**PLANNING & COMMUNITY DEVELOPMENT  
DEPARTMENT**

February 12, 2020

**RE: Templeton Gap Townhomes**  
**File: CPC PUZ 20-00012, CPC PUP 20-00013, CPC PUD 20-00014, AR FP 20-00054**

City Land Use Review Division staff has completed its initial review of the above application. This letter is to inform you of the following matters to be addressed regarding the application and associated documents. Listed below are the City Planning Department's review comments, along with those of other departmental and external agencies, which must be addressed prior to application approval.

DEVELOPMENT PLAN  
SITE PLAN

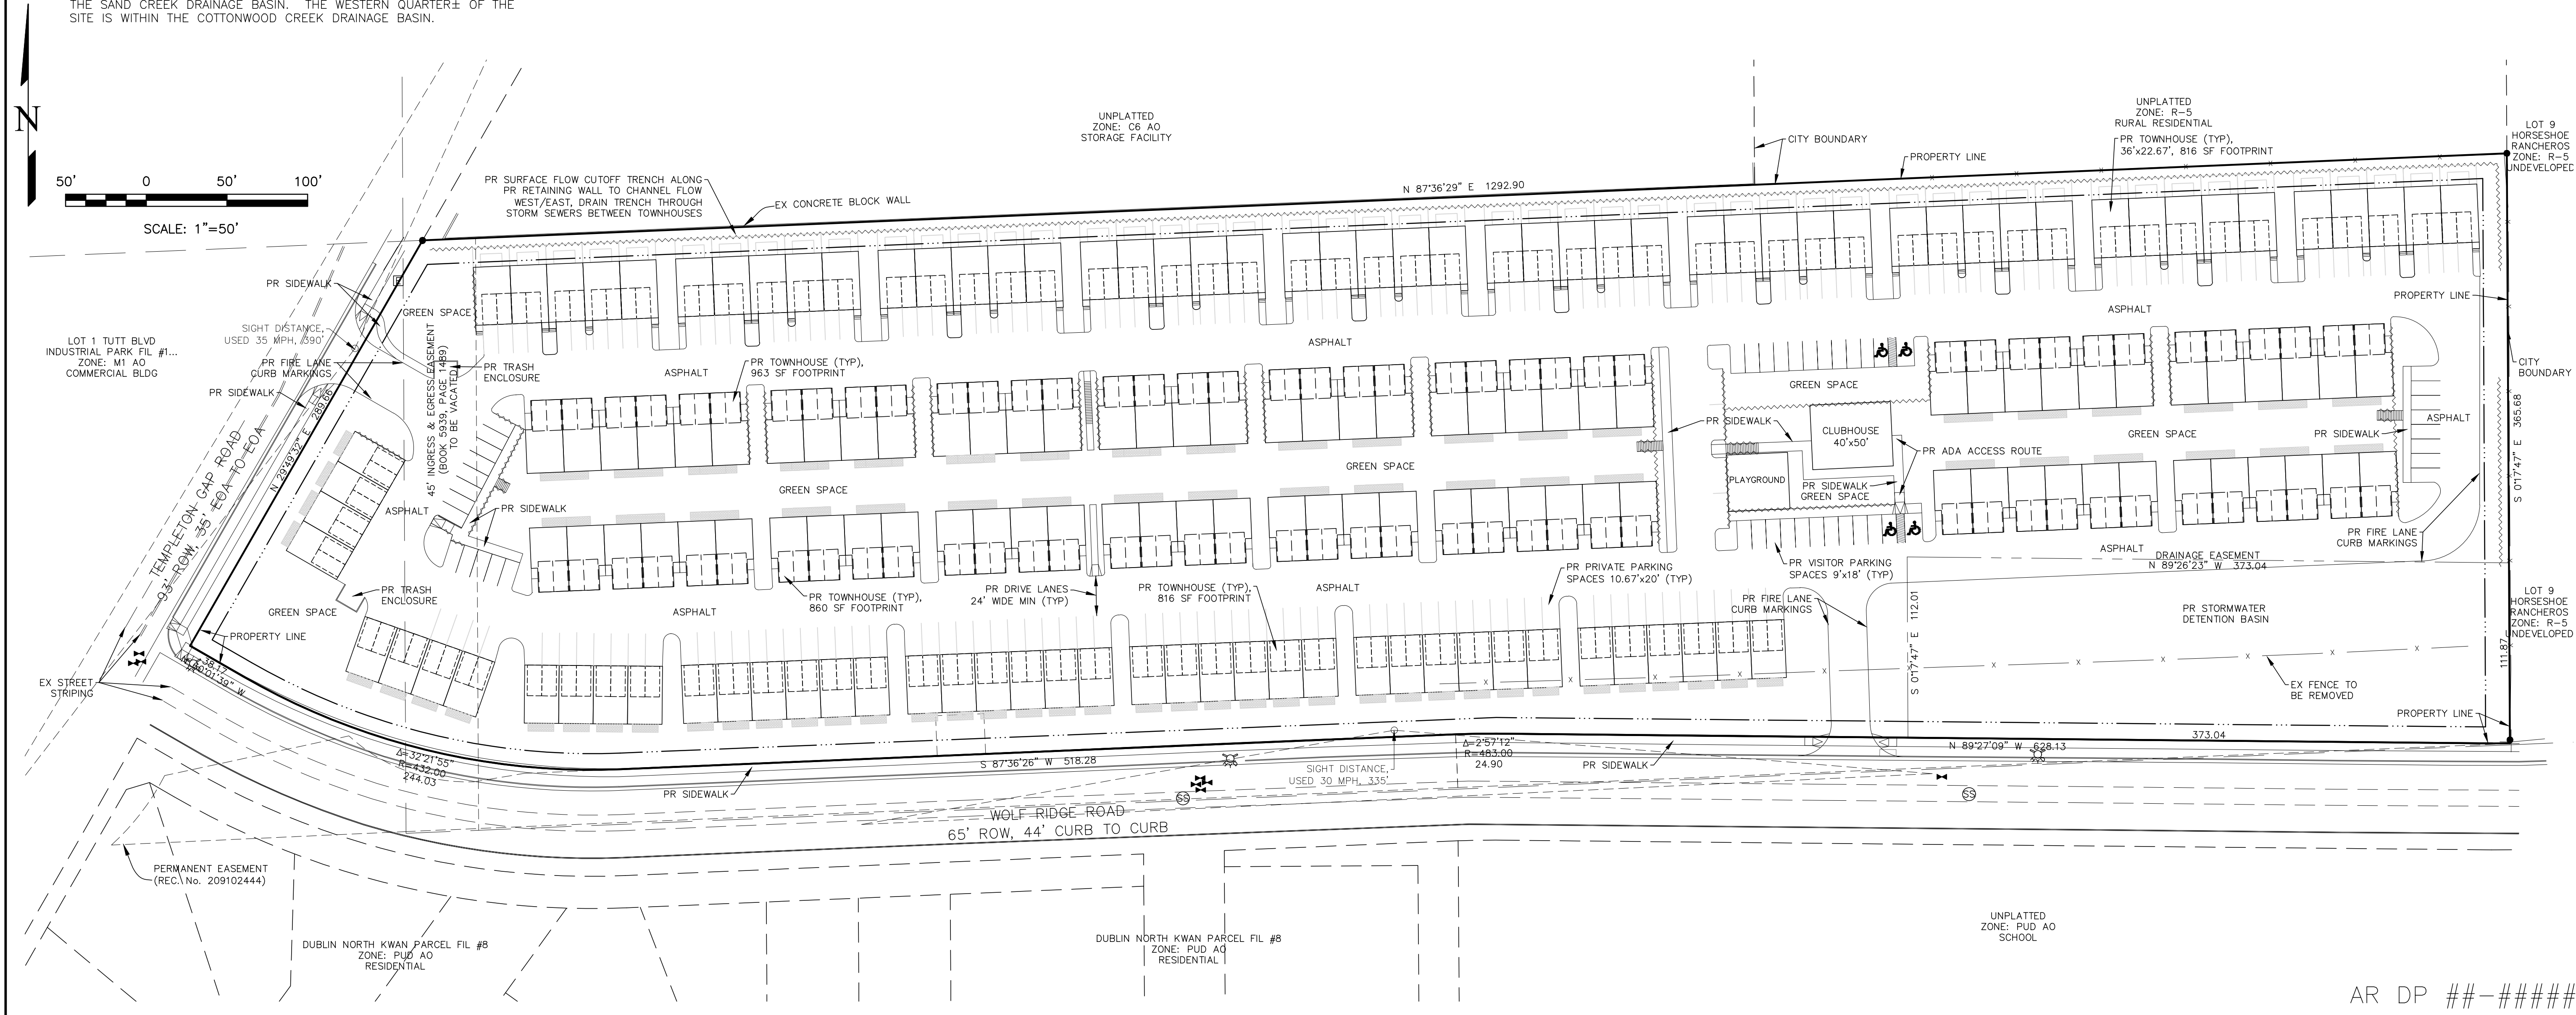
1- Please show and callout "on sheet 1 of the Development Plan" the speed line of sight with the adequate sight distance length (footage) for the proposed access along Wolf Ridge Road.

Moved the info to the correct location.

2- Please confirm "on sheet 1" that both proposed access points width are between 24-36 feet.

They are (these are scaled drawings, just measure them). The west entrance is 30' and the southeast entrance is 24'.

**TEMPLETON GAP TOWNHOMES**  
COLORADO SPRINGS, CO  
**PRELIMINARY GRADING PLAN**  
DECEMBER 2019

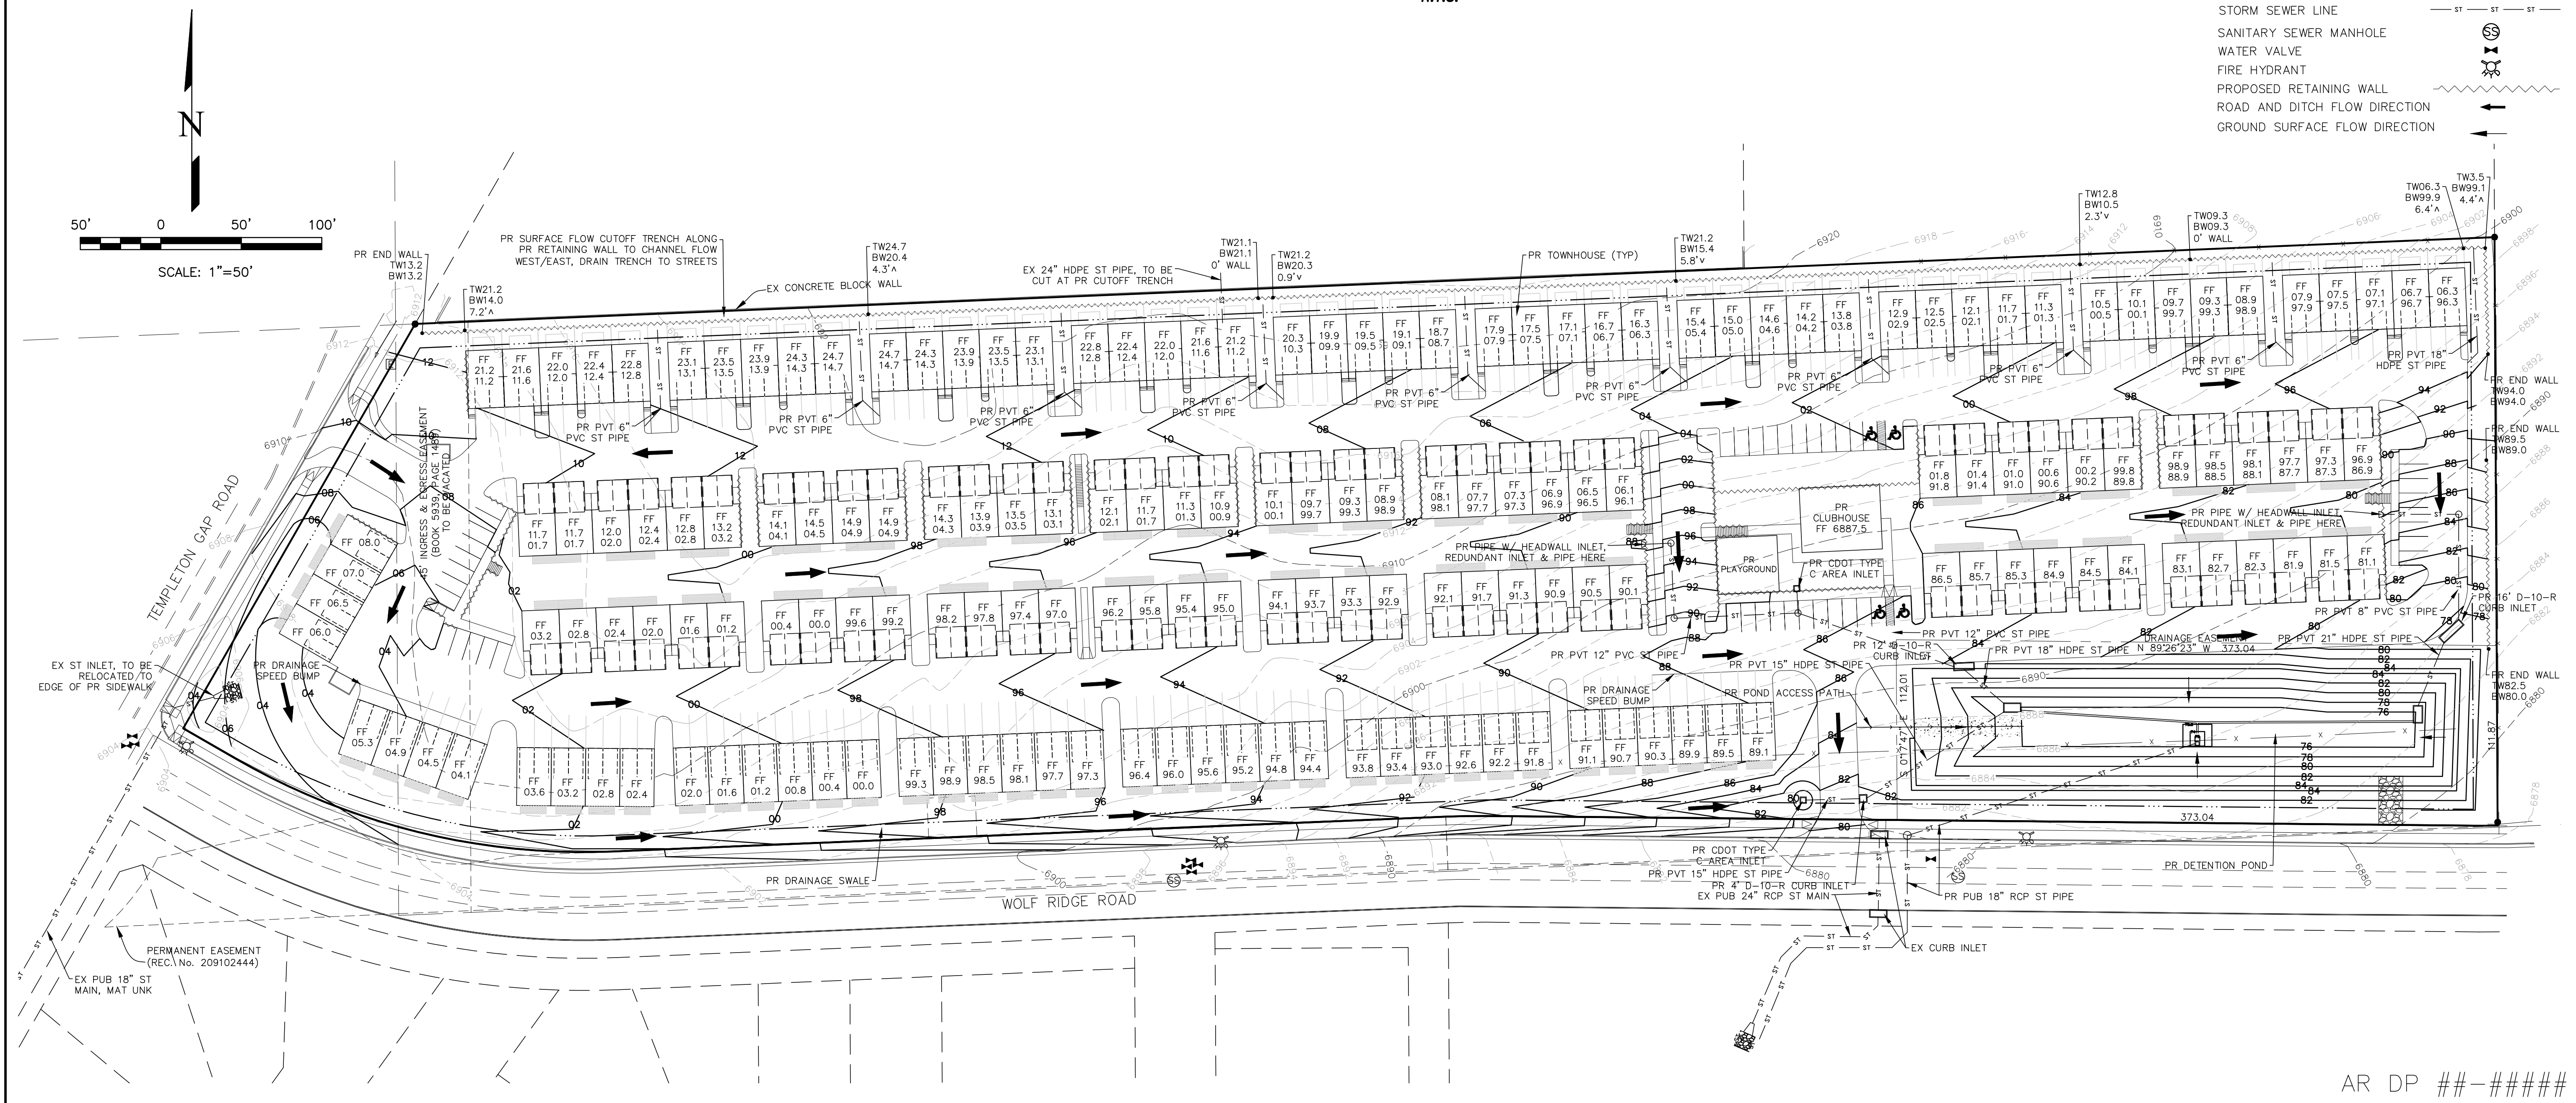
8. Update the retaining wall detail on the preliminary grading plan (sheet 2) by showing the proposed grade on the townhome side.

The proposed grading on the townhouse side is variable. In some areas the retaining wall raises the grade, in other it lowers the grade (ranges from +7.2' to -5.8'). I can't show variable grading for 1200+' of wall on a typical cross section. Generally speaking, the backyards against this retaining wall will be graded toward the retaining wall at 2% and toward the nearest landscaping strip on the side for drainage (basically flat, with just enough slope to drain away from the buildings).

10. The proposed outfall from the water quality facility is daylighting onto School District 49 private property. Assure this is acceptable to the school district, on sheet 2 clearly label the ownership of the property, show and callout the drainage easements. School District 49 will have to give written approval to allow the installation on their property.

There are existing public drainage facilities and an easement at this location, and the site already drains through these facilities. The easement has been added to the plan.

Figure 9
Conceptual Pedestrian Crossing
Galiant Townhomes (LSC #194450)

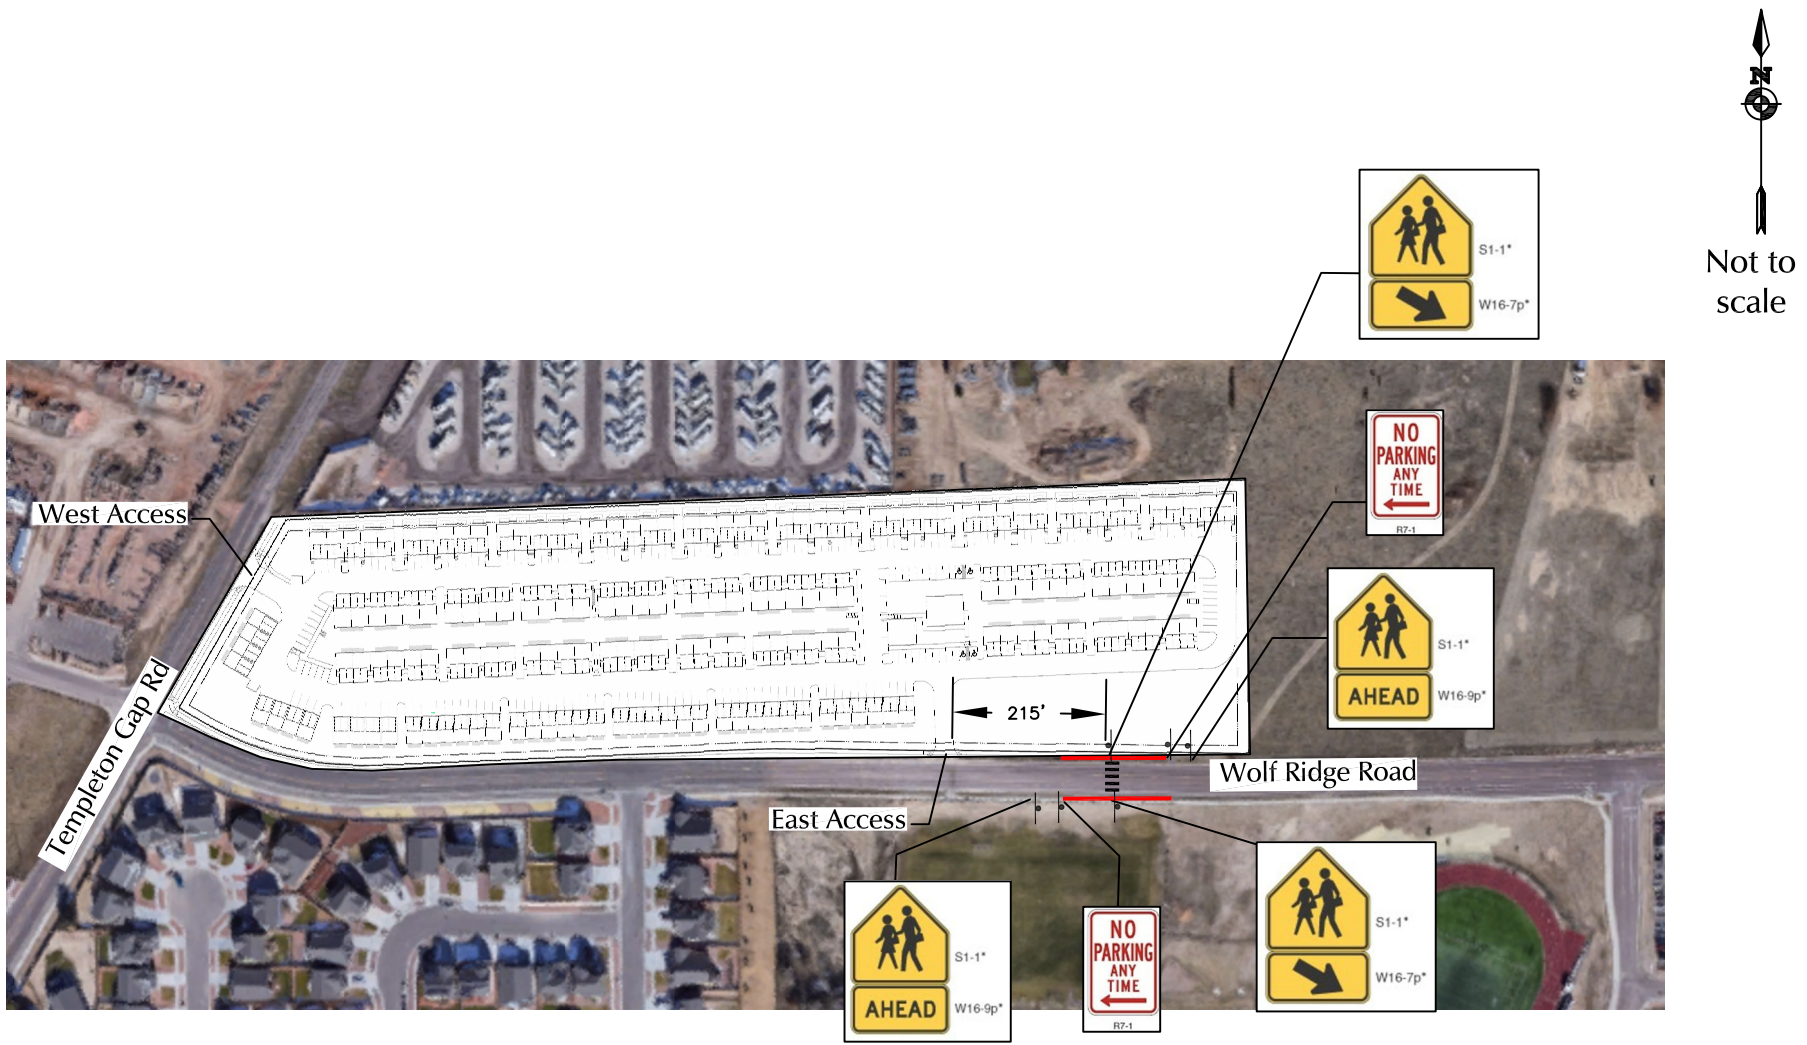
3- Please analyze a pedestrian crossing location to Vista Ridge High school campus.

LSC Response: It is recommended that a pedestrian crossing be placed approximately 215 feet east of the proposed access. This location is at the top of a vertical curve, maximizing sight distance for pedestrians and drivers. The crossing should have crosswalk striping and be signed with pedestrian crossing signs (S1-1) and a supplemental diagonal arrow (W16-7P). See the updated report for additional information.
